MEMORANDUM

DATE: March 2, 2023

SUBJECT: El Paso County Development Reviews; PO # 8115428
Owl Place (Meridian) Storage Rezone Traffic Impact Study (CS224)
First Review

SITE PLAN

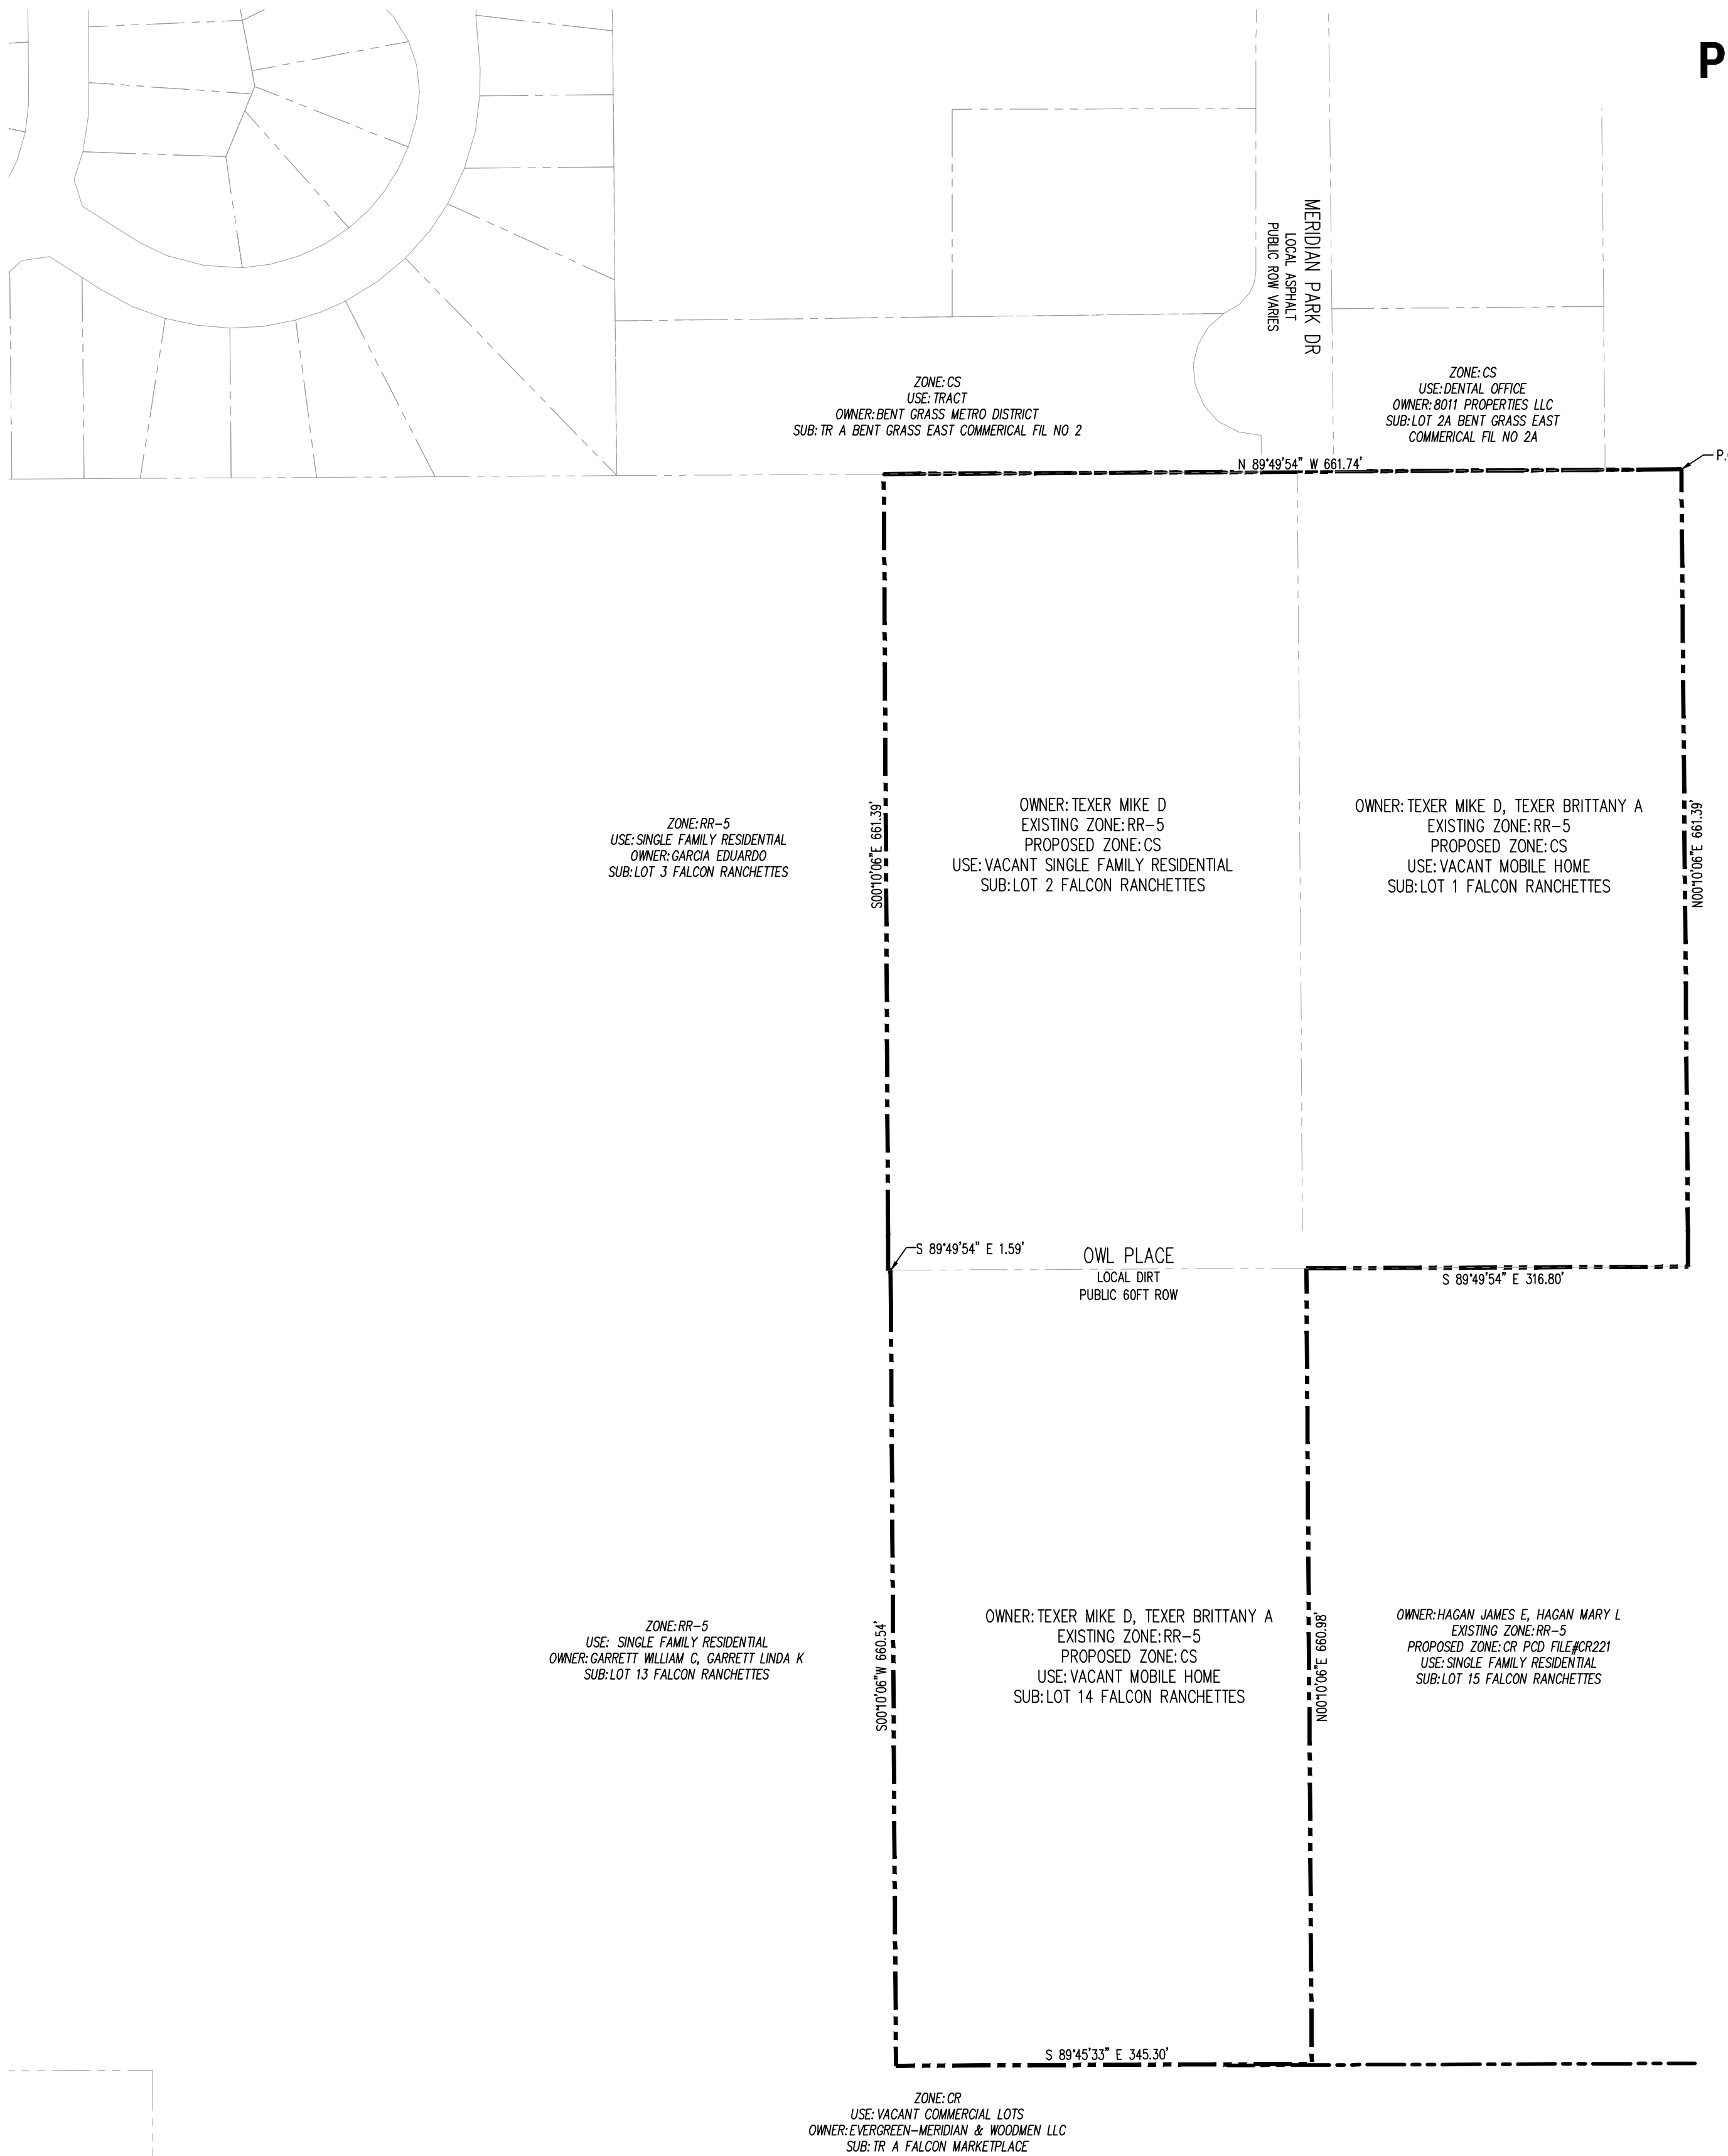
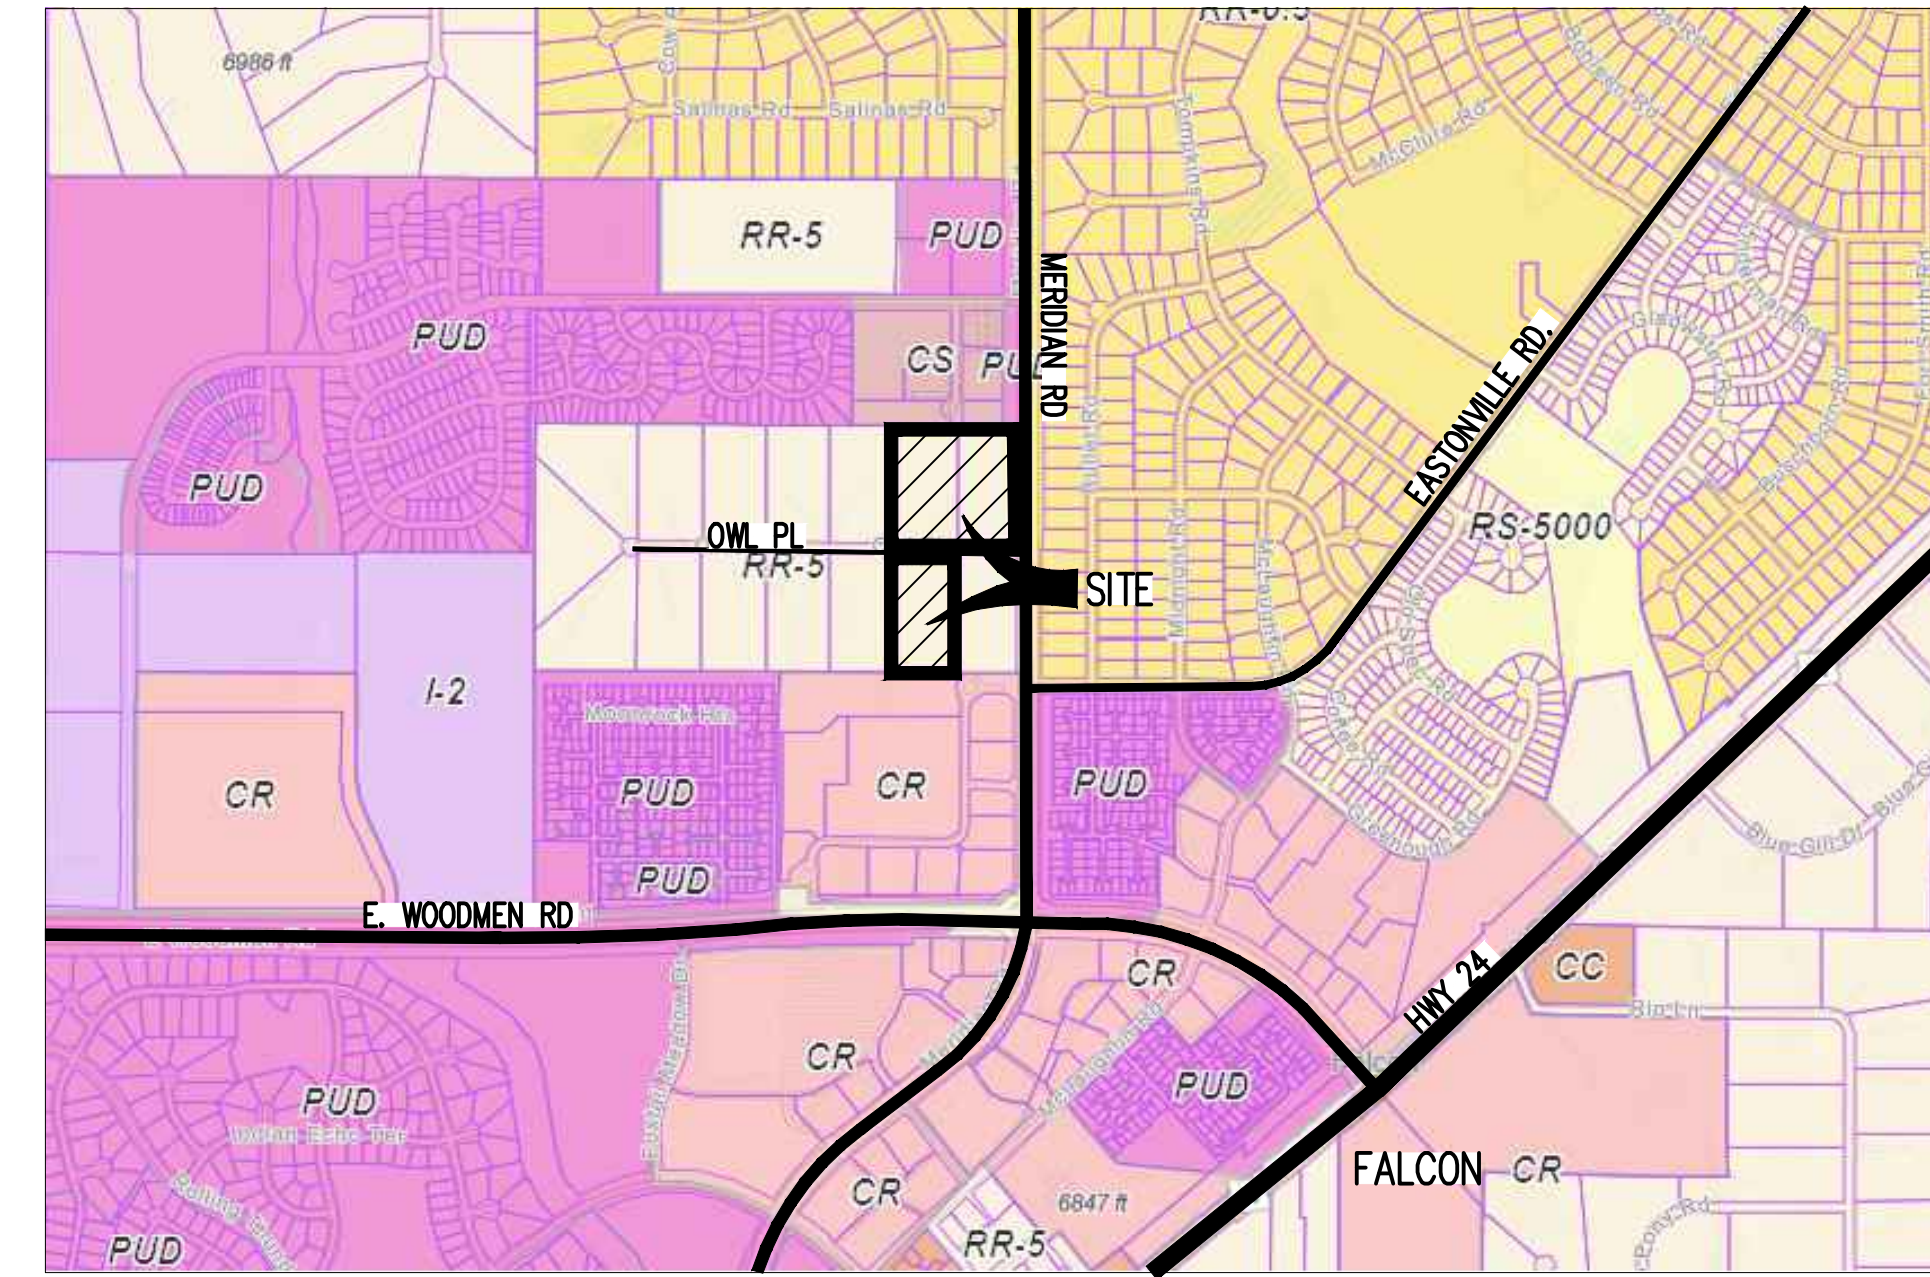
3. The applicant does not adequately describe or evaluate future conditions per ECM Section B.3.2.
 - a. The southerly access to Owl Place is clearly described, but how those trips will circulate past Owl Place is unclear. The site plan shows a future southerly connection to Eastonville Road that is briefly mentioned in Section IV of the TIS, but the timing, operations and responsibility for this connection are not described. This should be clarified.
